**Development Consent Order (DCO) application for the A12 Chelmsford to A120 widening scheme**

**Deadline 6**

This cover letter has been prepared by the Applicant to accompany the Applicant's submission to the Planning Inspectorate for Deadline 6 of the Examination for the A12 Chelmsford to A120 widening scheme. This is in accordance with the requirements set out by the Examining Authority in the written questions and requests for information (ExQ3) issued on the 22<sup>nd</sup> of May 2023.

Drawing title
**TRAFFIC REGULATION MEASURES
SPEED LIMITS
SHEET 14 OF 21**

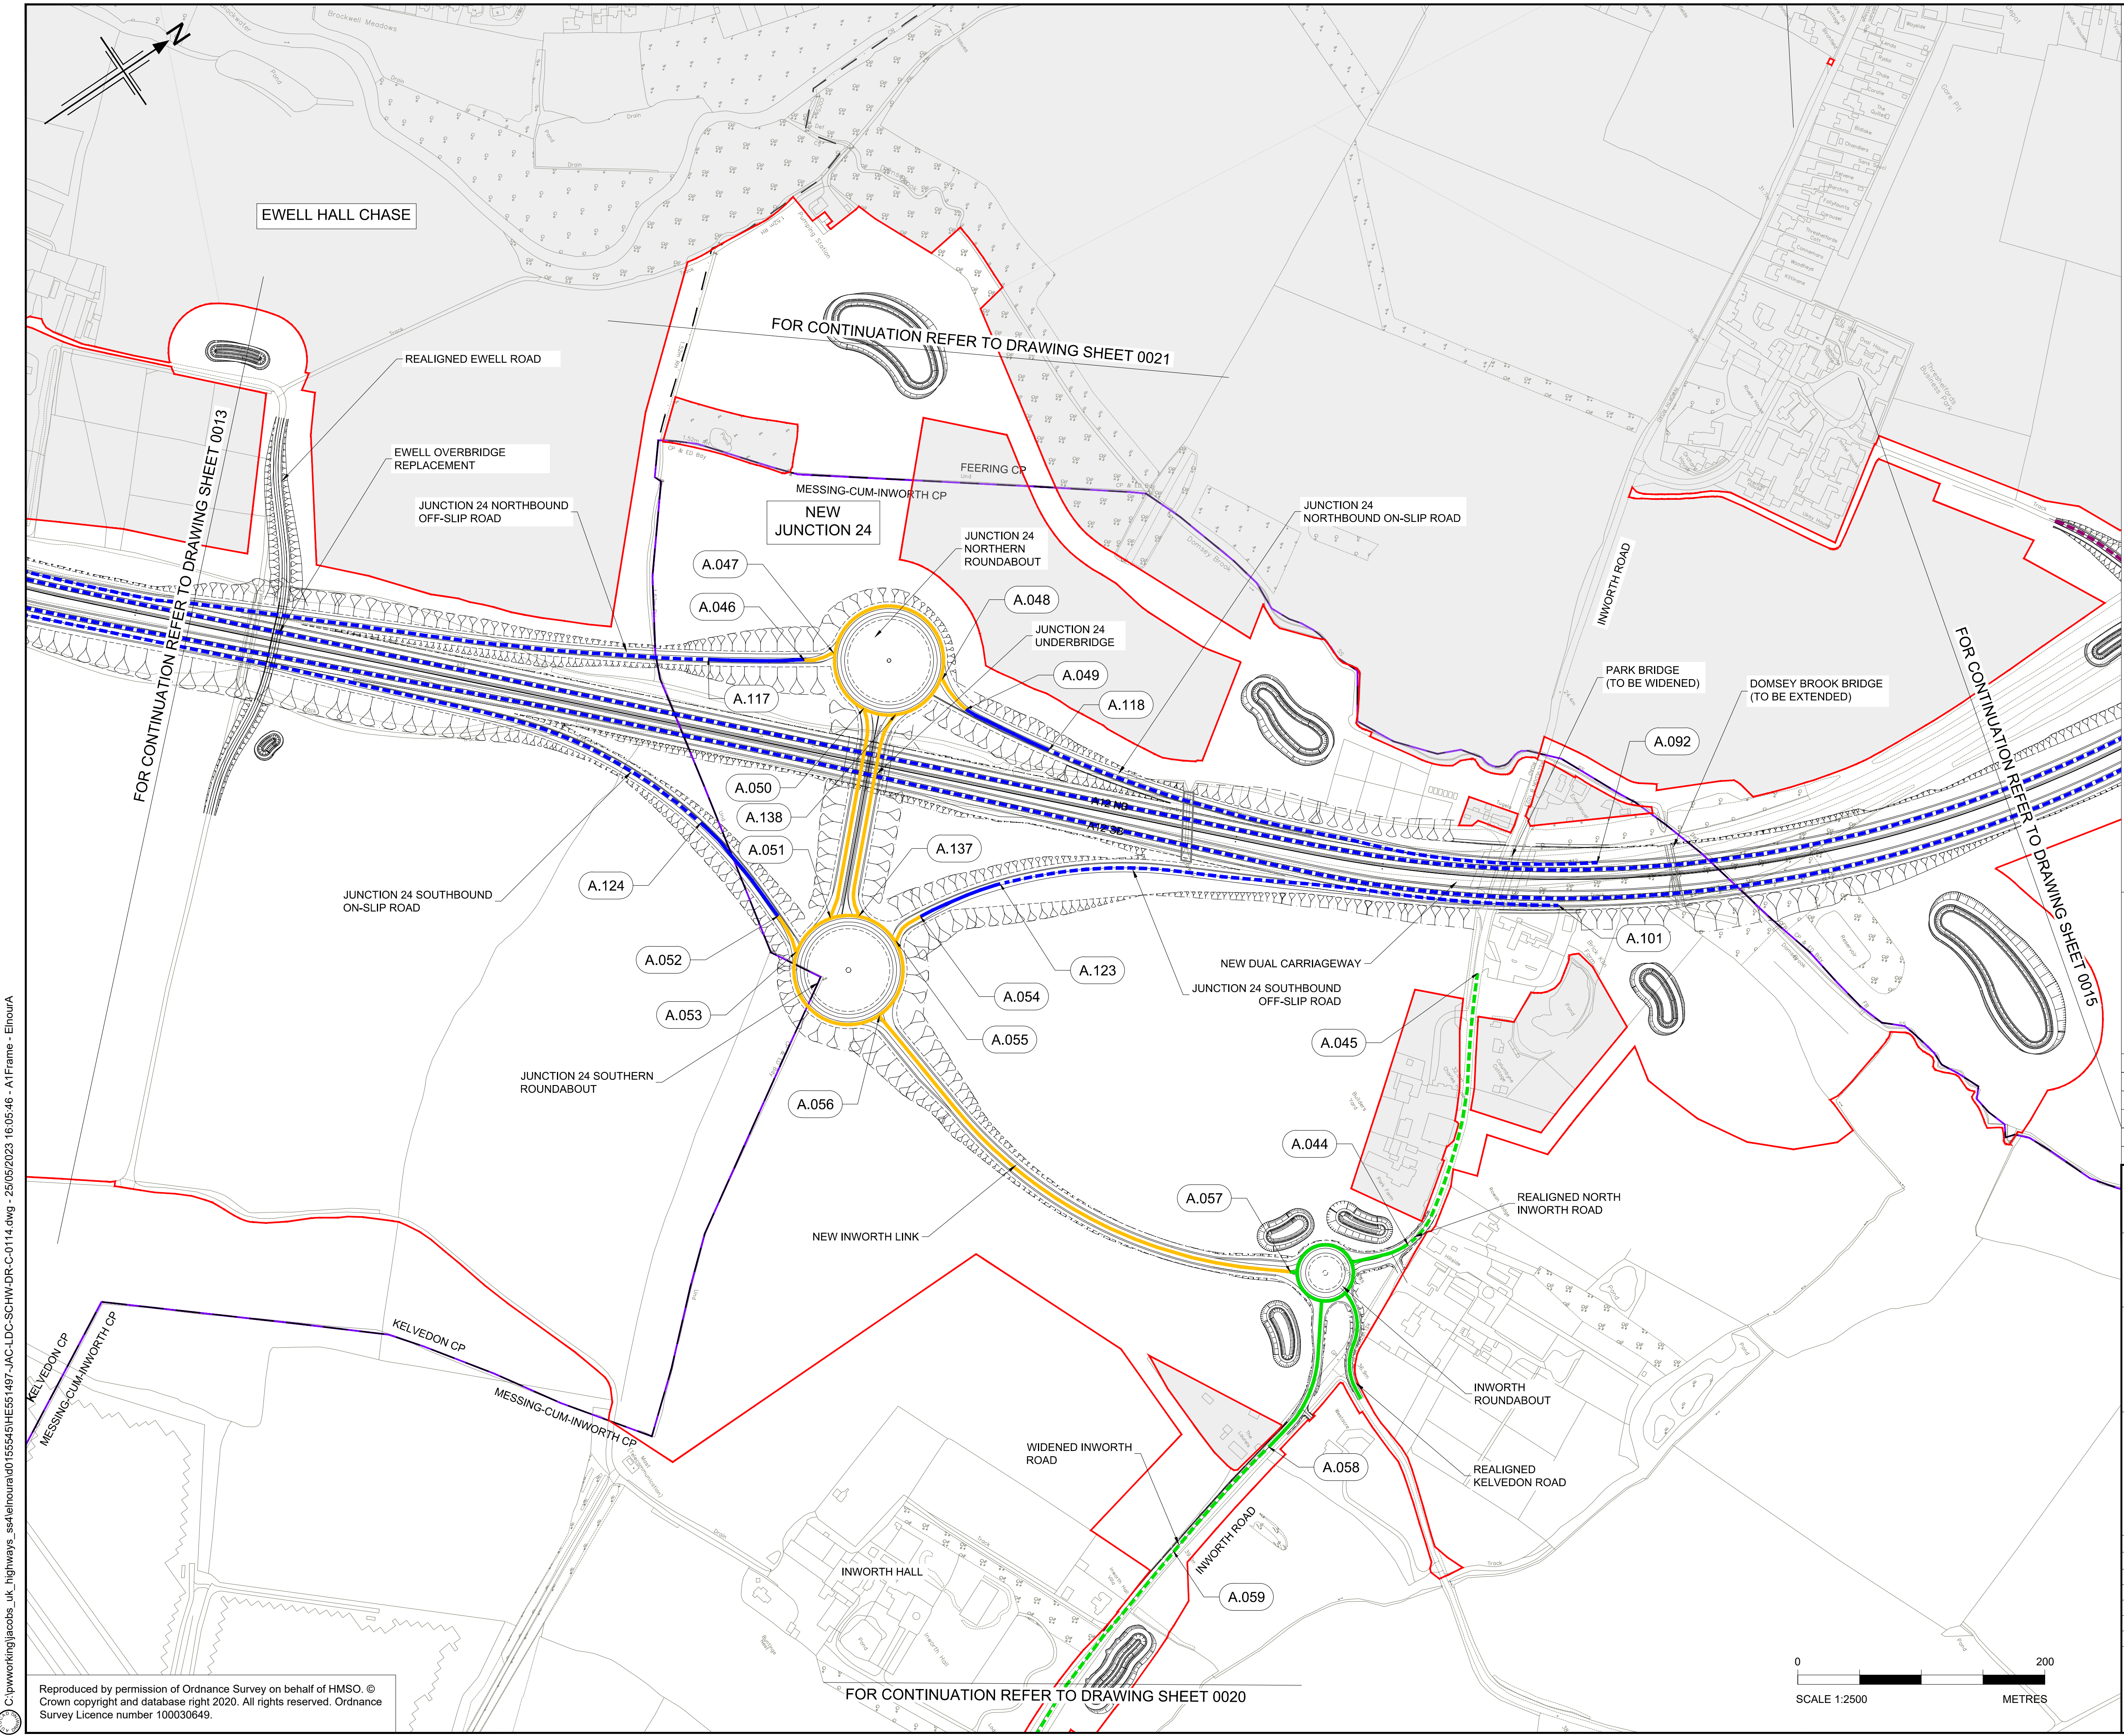
Sheet 6, 7, 10, 14, 18 & 19

- Errata item - Start of variable speed limit order has been updated to correct extents.

Drawing title: **STREETS, RIGHTS OF WAY AND ACCESS PLANS SHEET 14 OF 21**

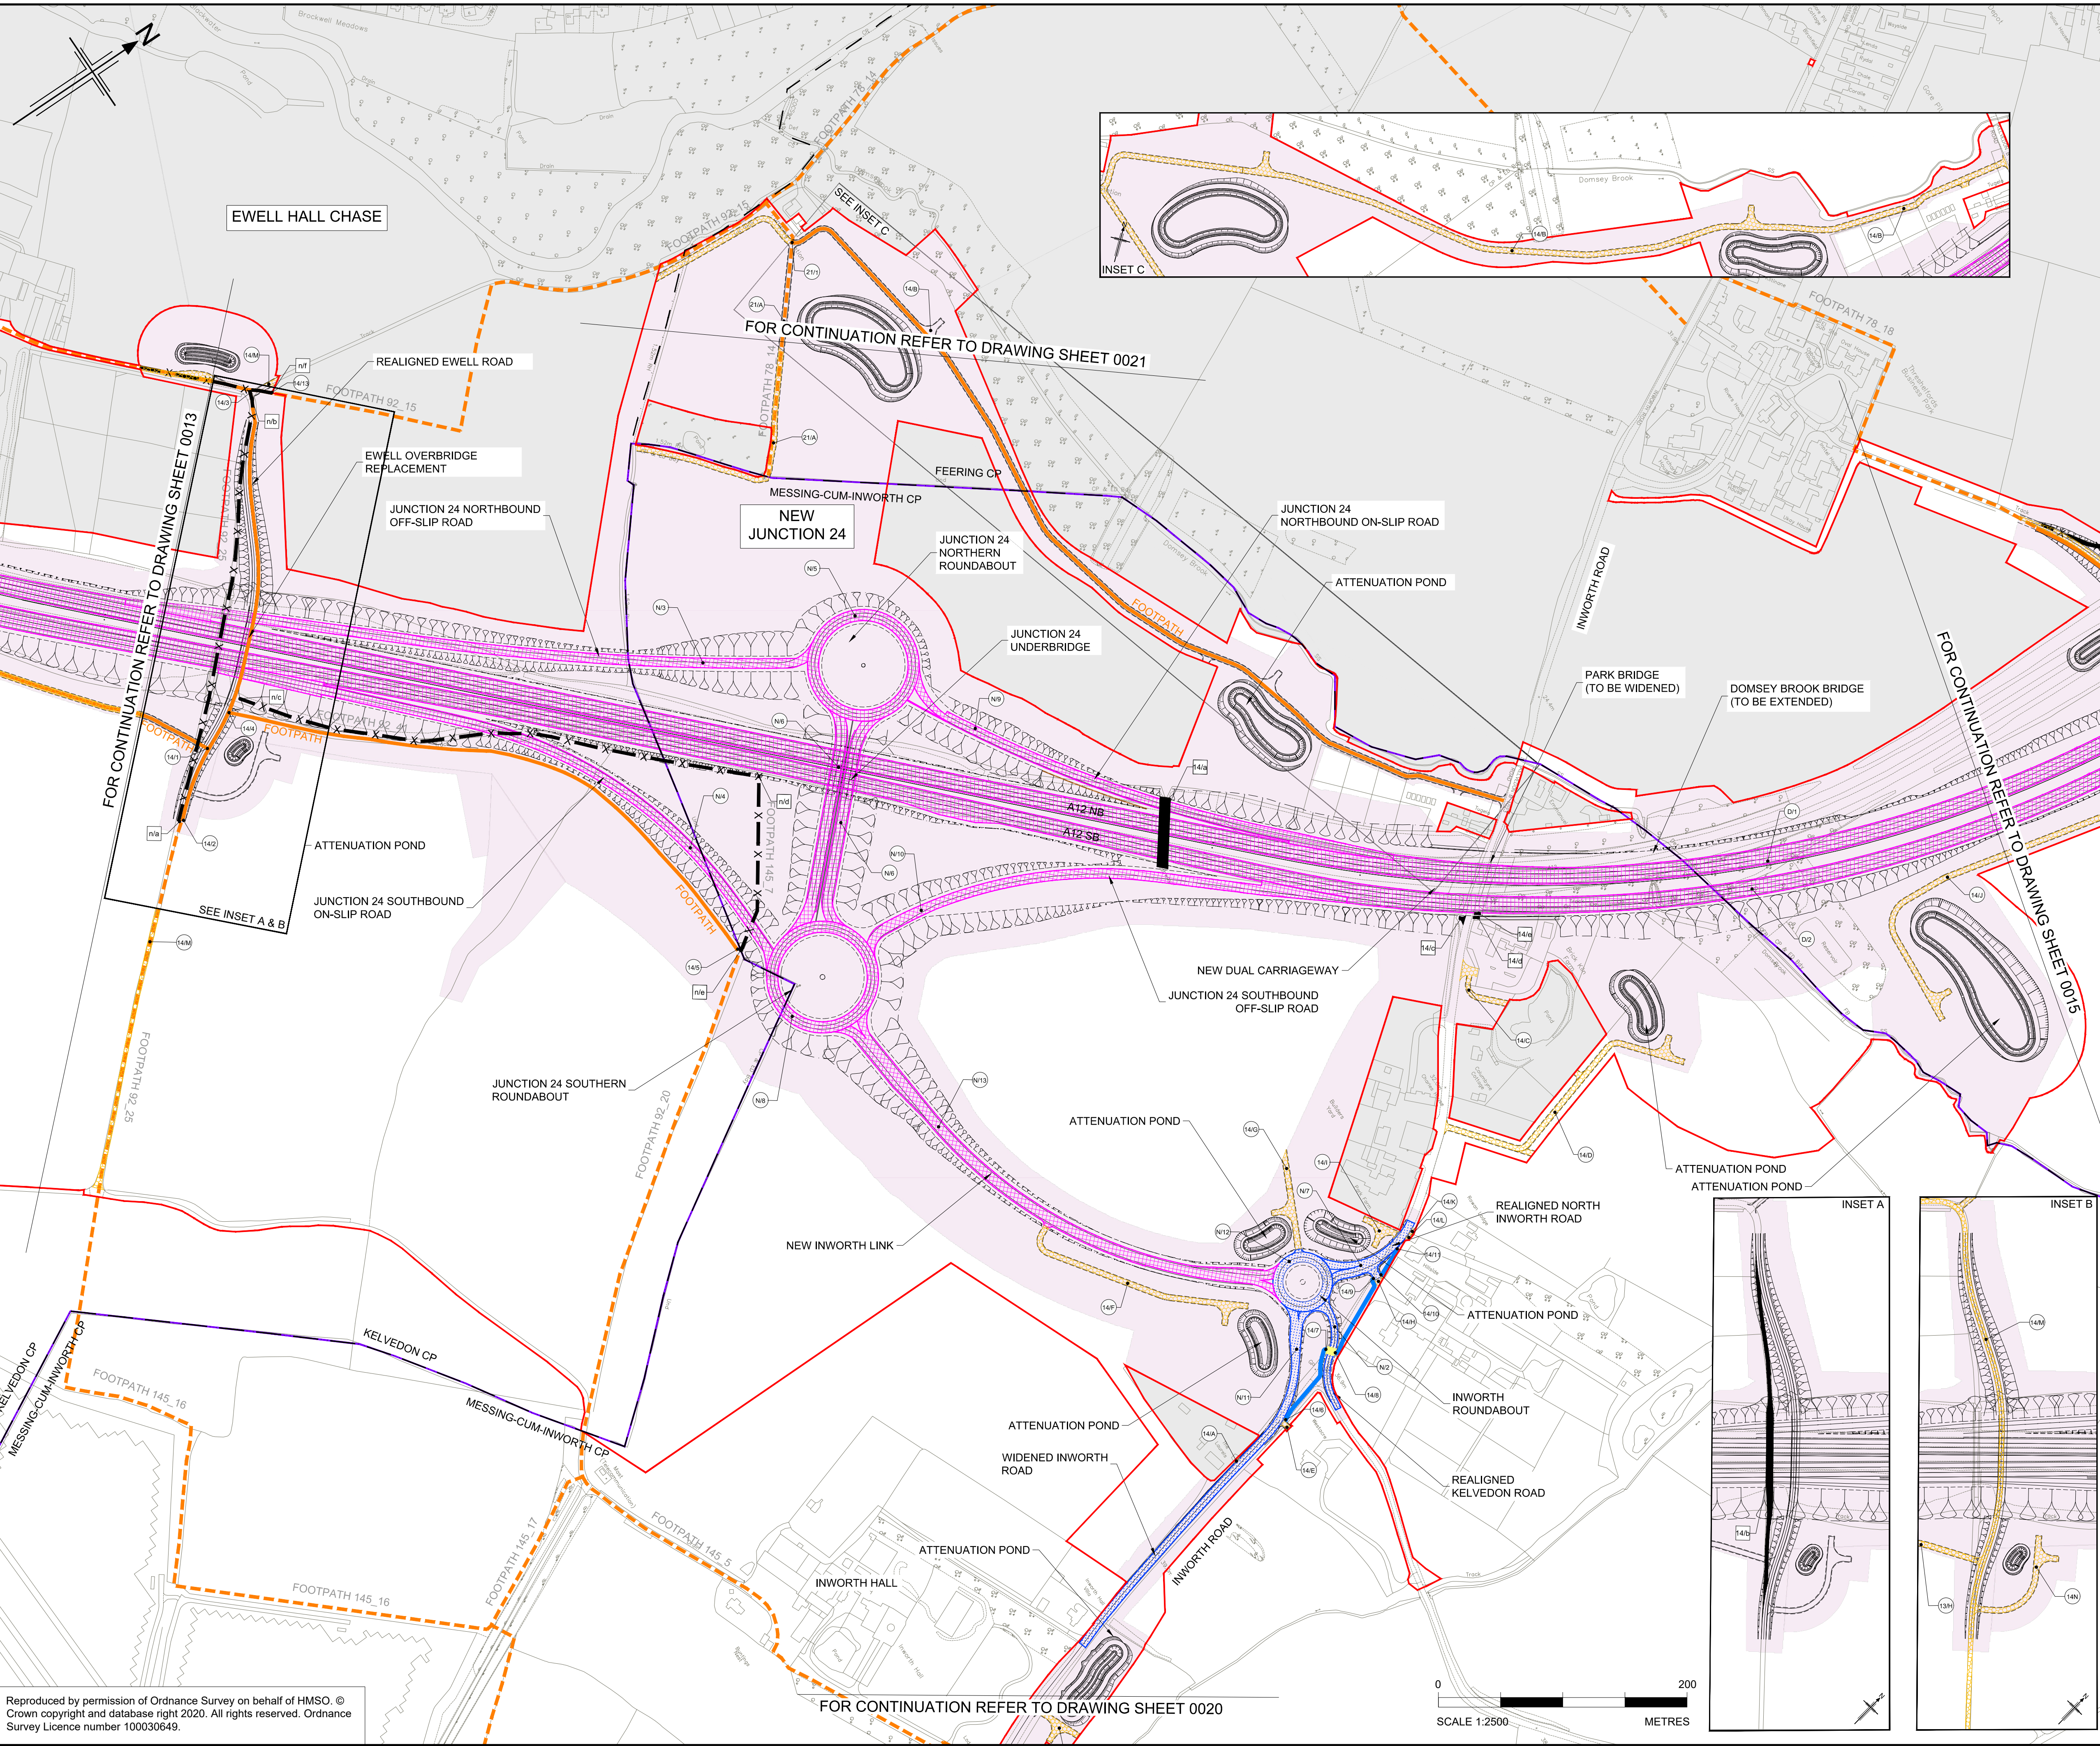
Sheets 2, 7, 14, 15, 18 and 19

- Errata item - amendments to address discrepancies in labelling and drawing clarity
